FIELD OBSERVATION REPORT
Price Structural Engineers, Inc.

Project: 3 – Unit Apartment
Location: 62 Cumberland St.; Portland, ME
Date: January 26, 2010
Time: 1:00 PM

Steel Installation and Initial Wood Framing

**H1** FOUNDATION PLAN 1/4" = 1'-0"

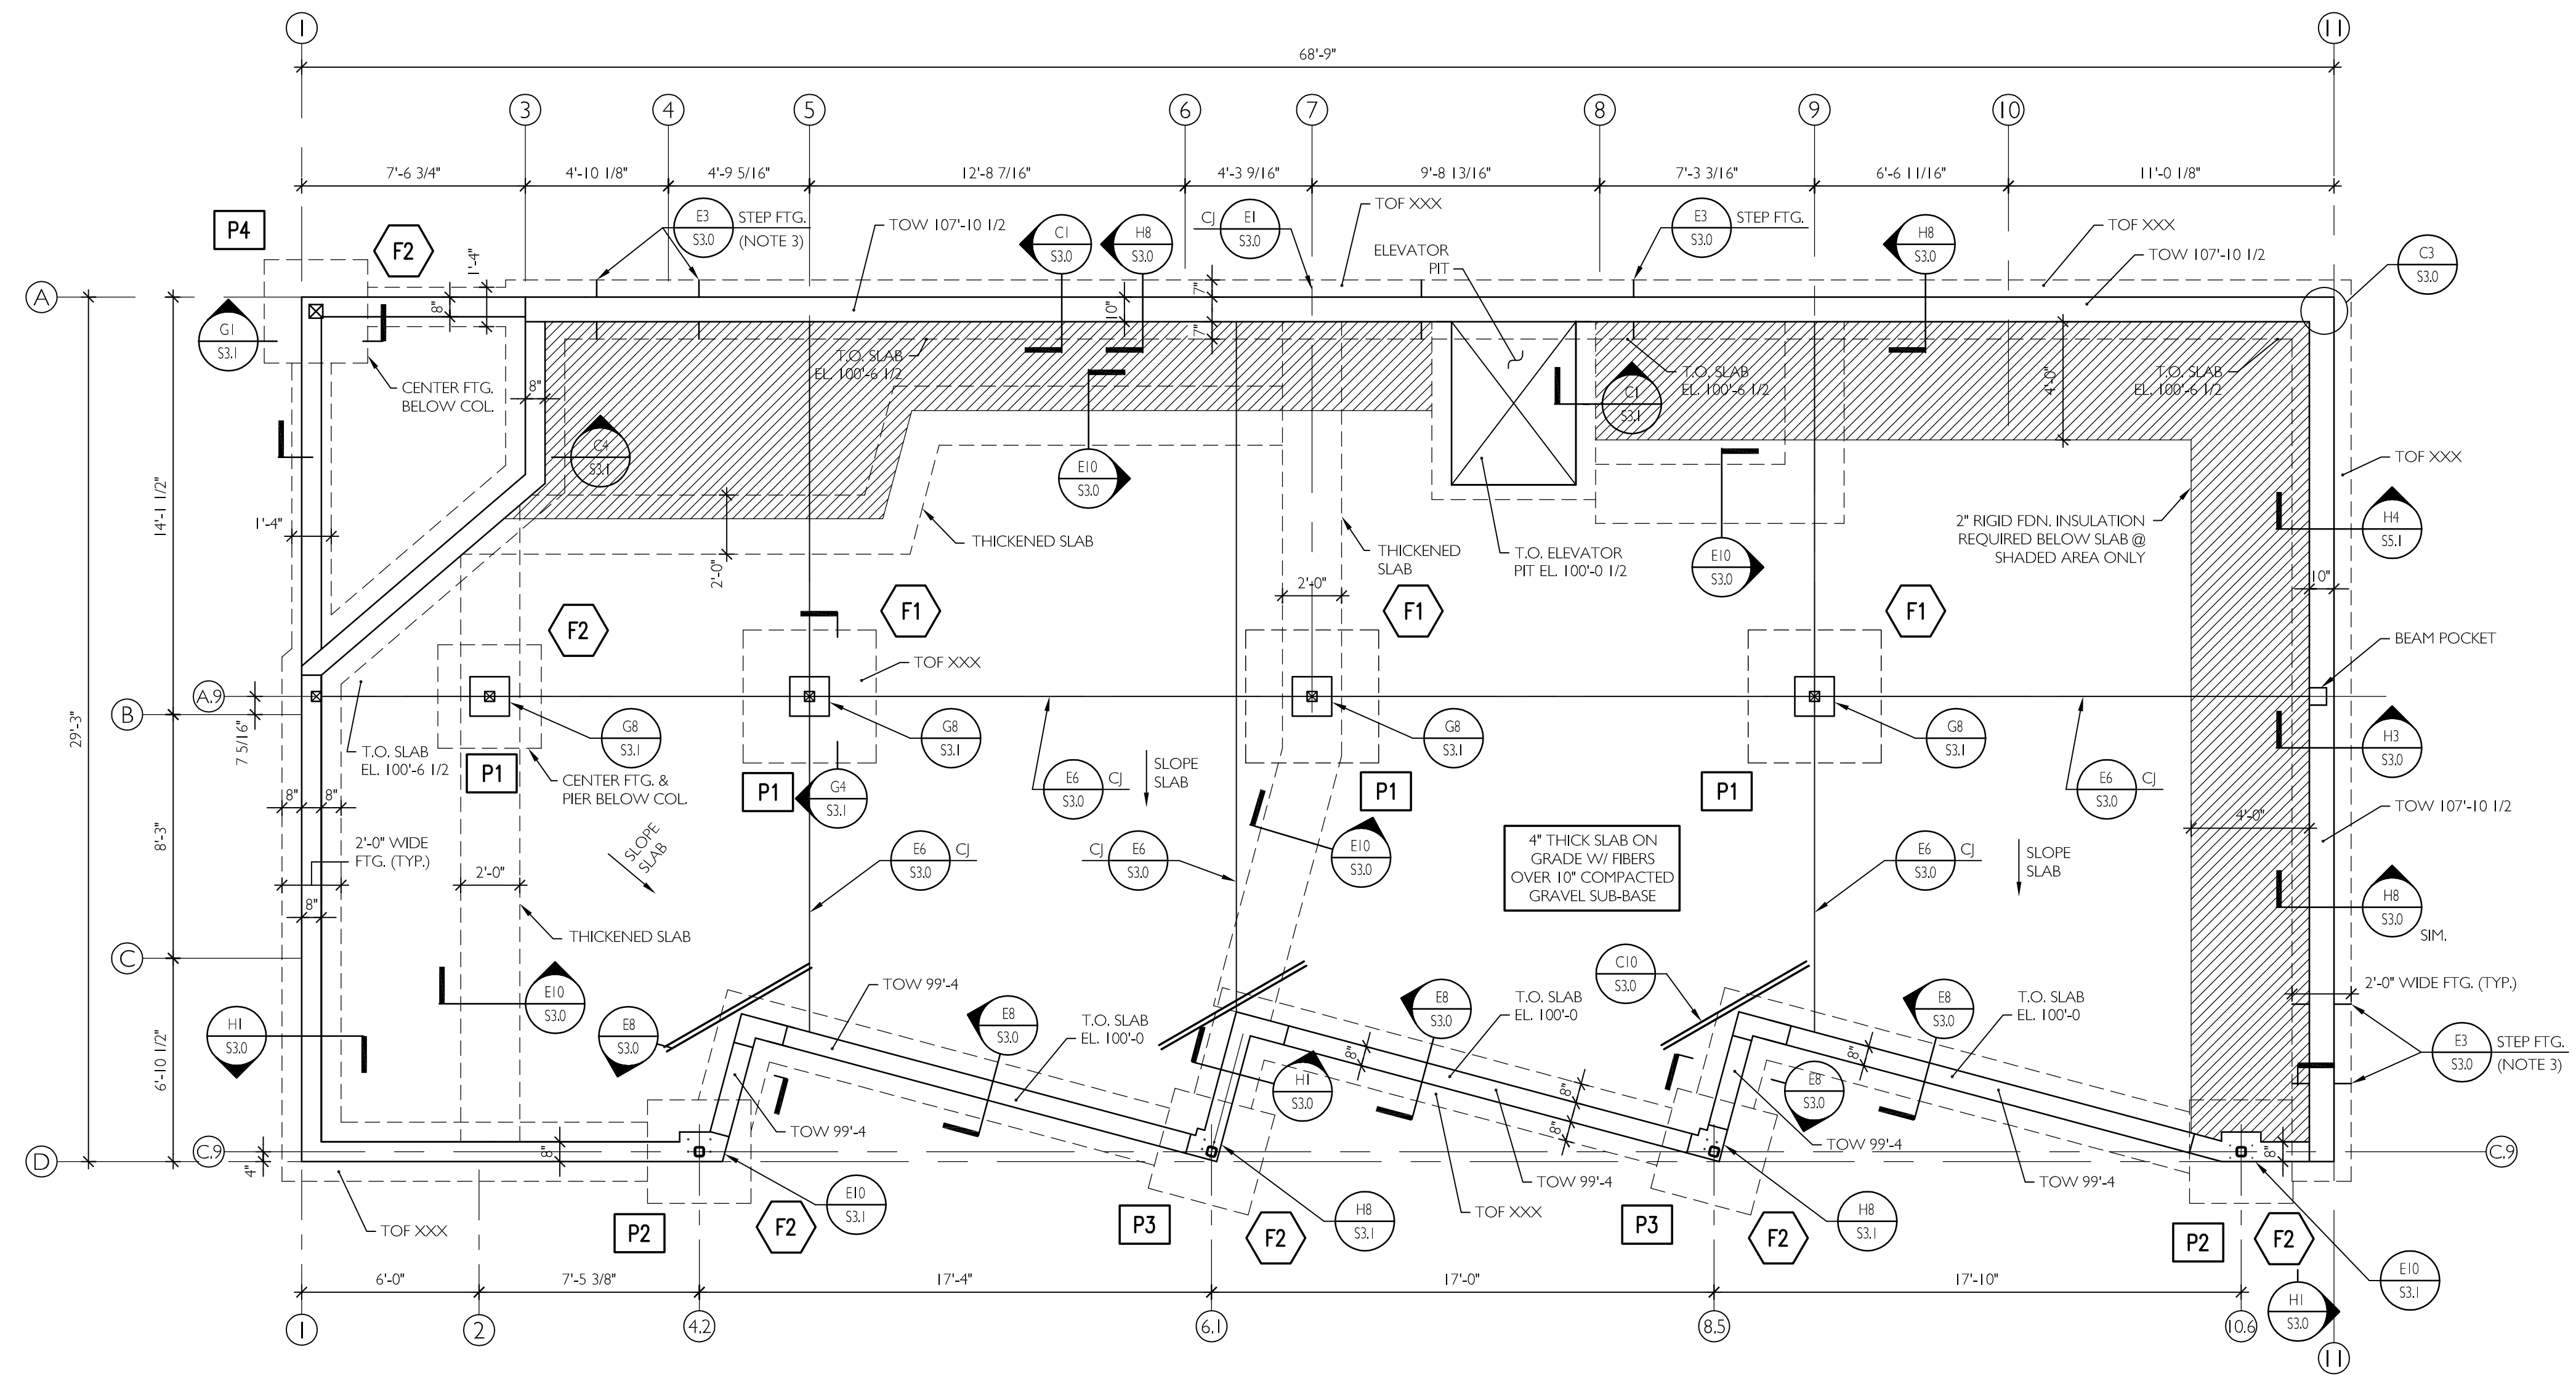
3. Deep snow currently providing frost protection for footings in addition to insulated blankets.
4. Concrete pocket for steel beam was installed too low at grid 11/A.9. See "Correction Items" below.

1. Steel beam pocket at grid 11/A.9 was placed too low. Contractor shall provide adequate temporary support of steel beam and infill void below beam with solid concrete (f'c = 4000 psi). The temporary shoring shall remain in place until concrete has cured a minimum of 7 continuous days unless 2% accelerator or "high early" concrete is used in concrete mix design which would reduce curing period to 3 days.
2. Missing anchor bolts – install 3/4" diameter Hilti Kwik bolts with 4" embedment in concrete per Hilti requirements including, but not limited to hole diameter, cleaning of hole and nut tightness.

1. GC coordinated steel beam lengths to accommodate previous concrete piers that were not accurately placed per drawings
